From: Amanda Scholes on behalf of Planning.Responses
Sent: 17 March 2021 14:18
To: Planning Scanning
Subject: FW: BR/307/20/PL - Butlins kiosk - CDC ECOLOGY COMMENTS

From: Stephanie Evans [REDACTED]
Sent: 18 February 2021 11:45
To: Amy Myer <Amy.Myer@arun.gov.uk>
Subject: RE: BR/307/20/PL - Butlins kiosk - CDC ECOLOGY COMMENTS

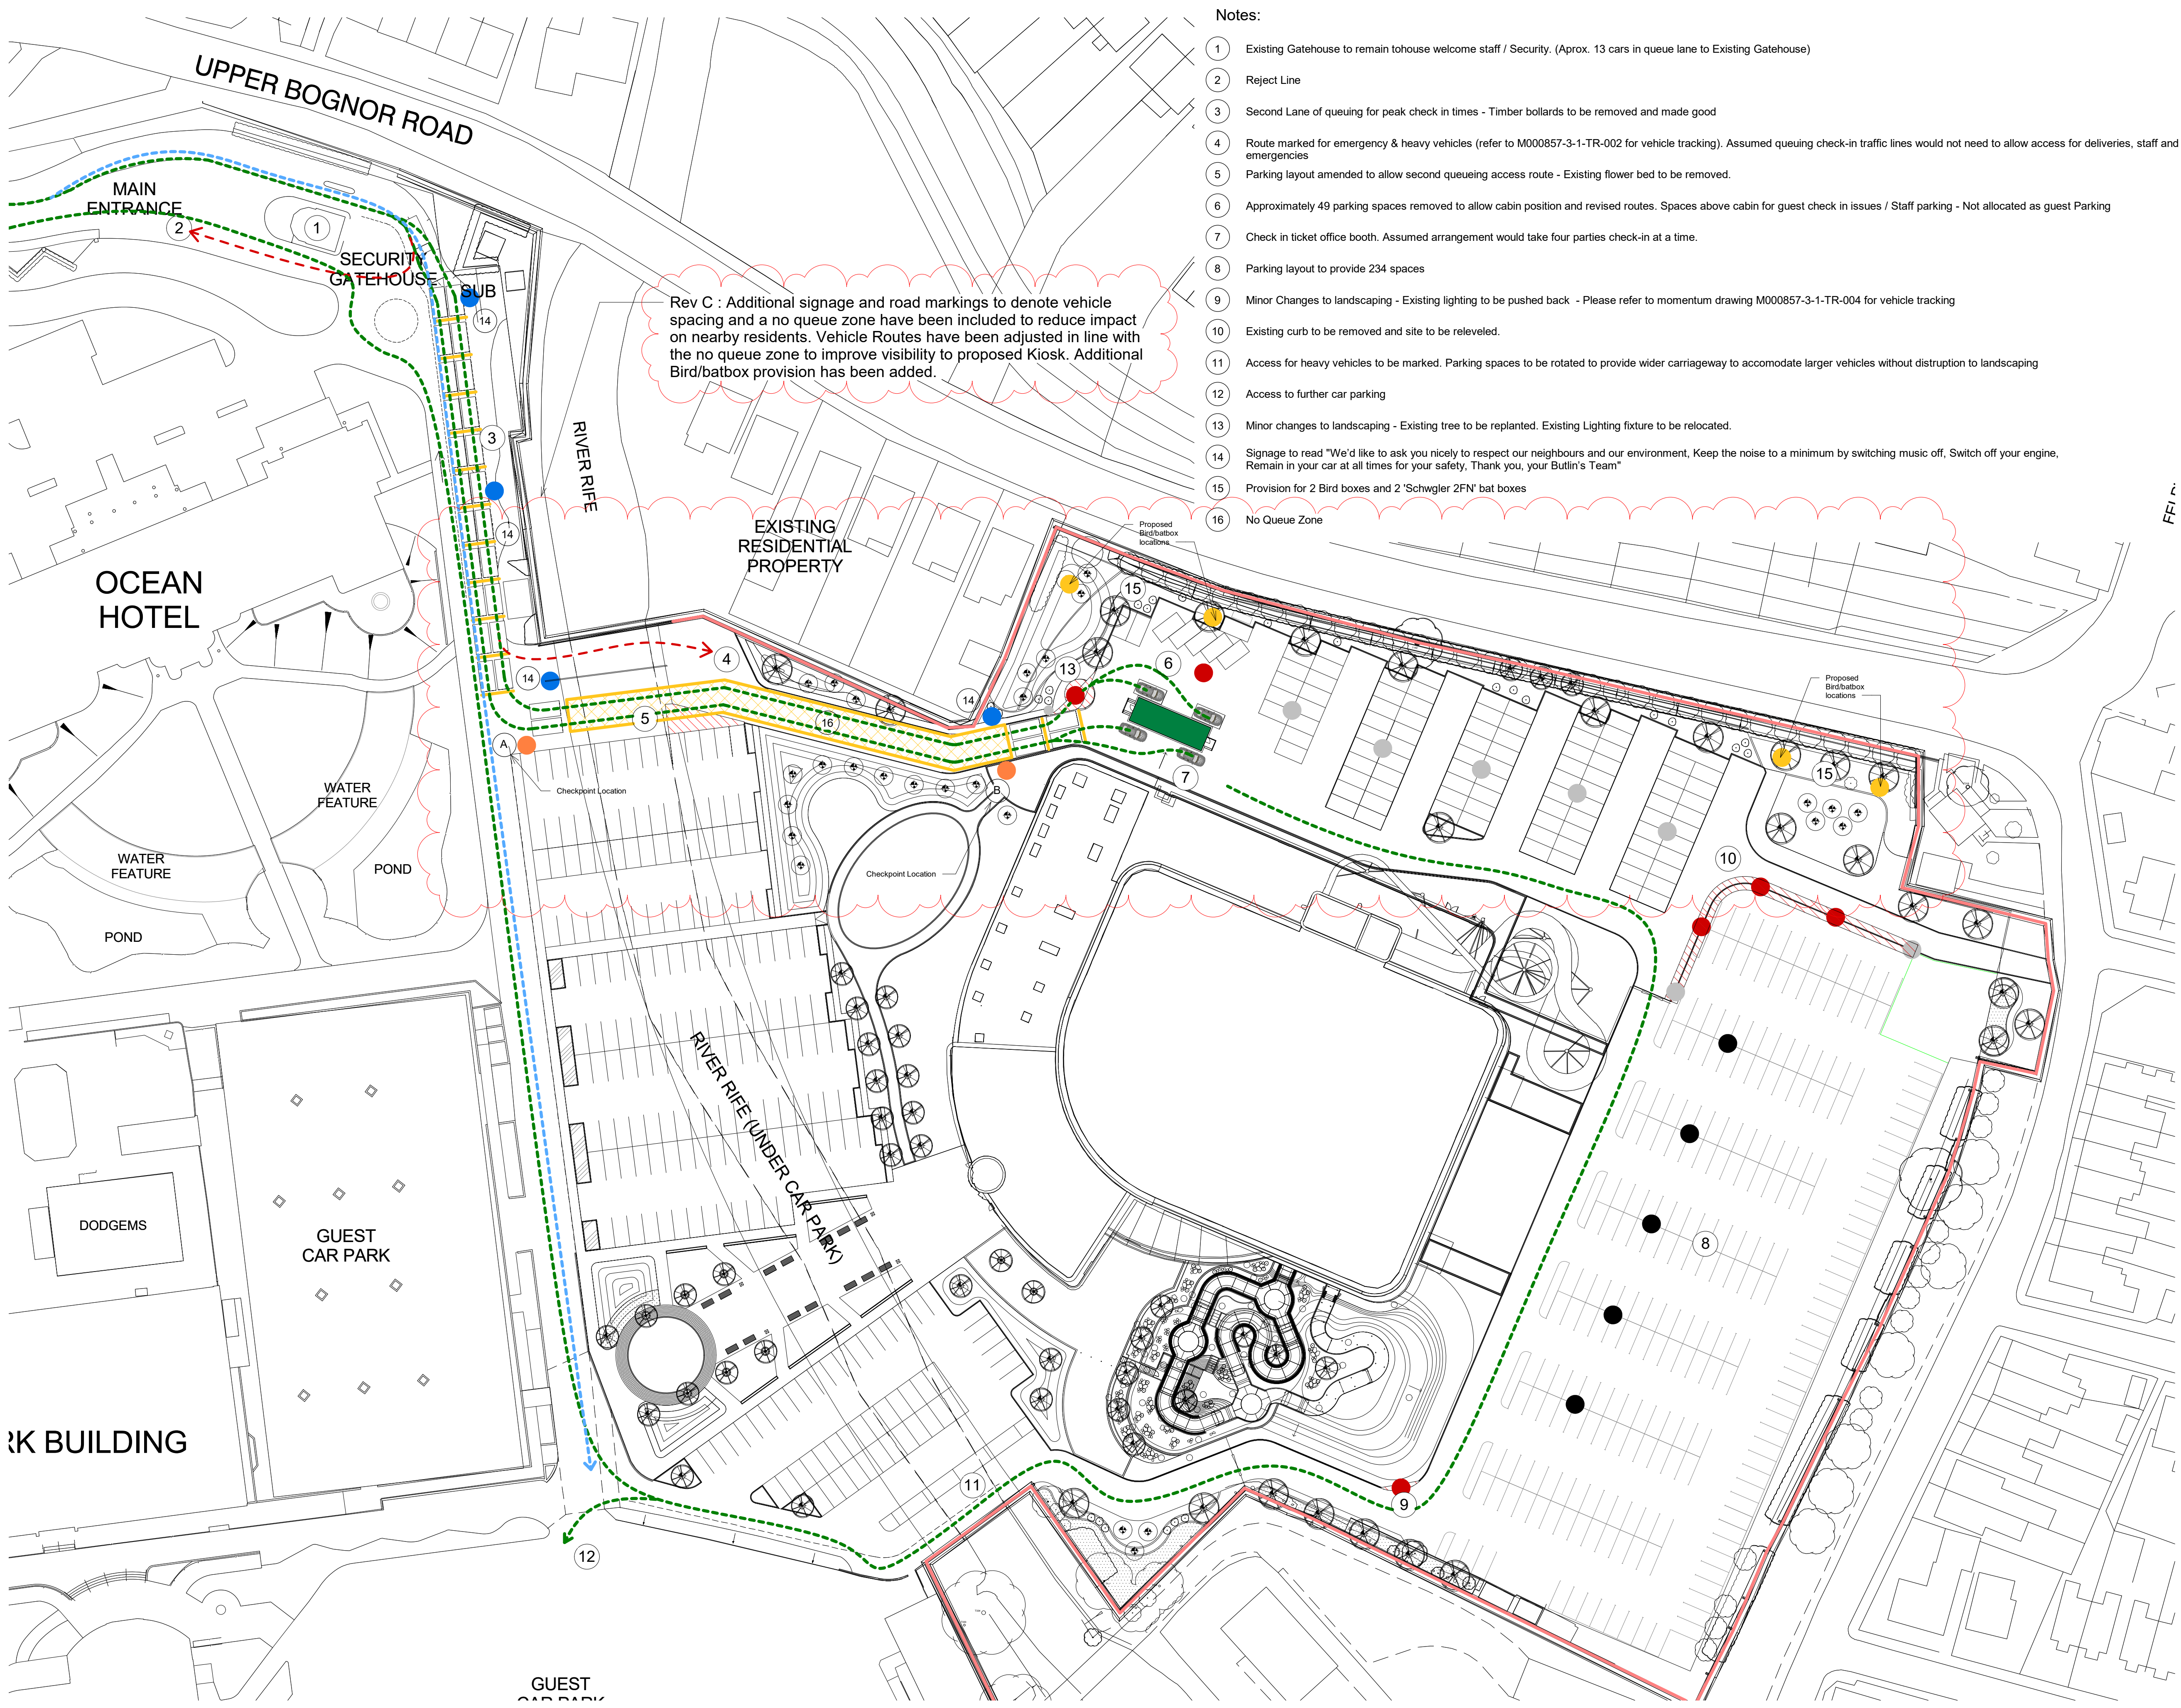
- *Our submitted plans show that there is no new car park lighting, in fact the red dots on plan WOO/MPN/BOG/DR/A/0010A show 2 existing lighting columns in the vicinity of the proposed new kiosk being moved further away from the rife. The only changes to the car park lighting are movements of existing columns/fittings. On that basis there is not any new lighting to detail.*
- *The proposal is for a small "flat pack" sectional building it is also only single storey – which seems a hardly appropriate location for bird or bat boxes. Boxes were installed on site as part of the pool scheme, is it really necessary for more as part of such a small scale scheme? If this really is important we can install a couple more of similar to those used for the pool but putting these in boundary locations seems preferable to on the building itself.*

I just wanted get back to you with comments regarding the above planning application. Whilst we do not have concerns regarding the application, due to the proximity of the site to the Lidsey Rife Biodiversity

Opportunity Area we would like to see a bat sensitive lighting scheme implemented and also the inclusion of bat/sparrow boxes within/on the new structure.

I think the lighting has been addressed, if there is not going to be any additional lighting. That is the lighting scheme, if you like.

In terms of the bird and bat boxes, these are needed to show net gain but I accept the boundary vegetation would be preferable and so can accept that.
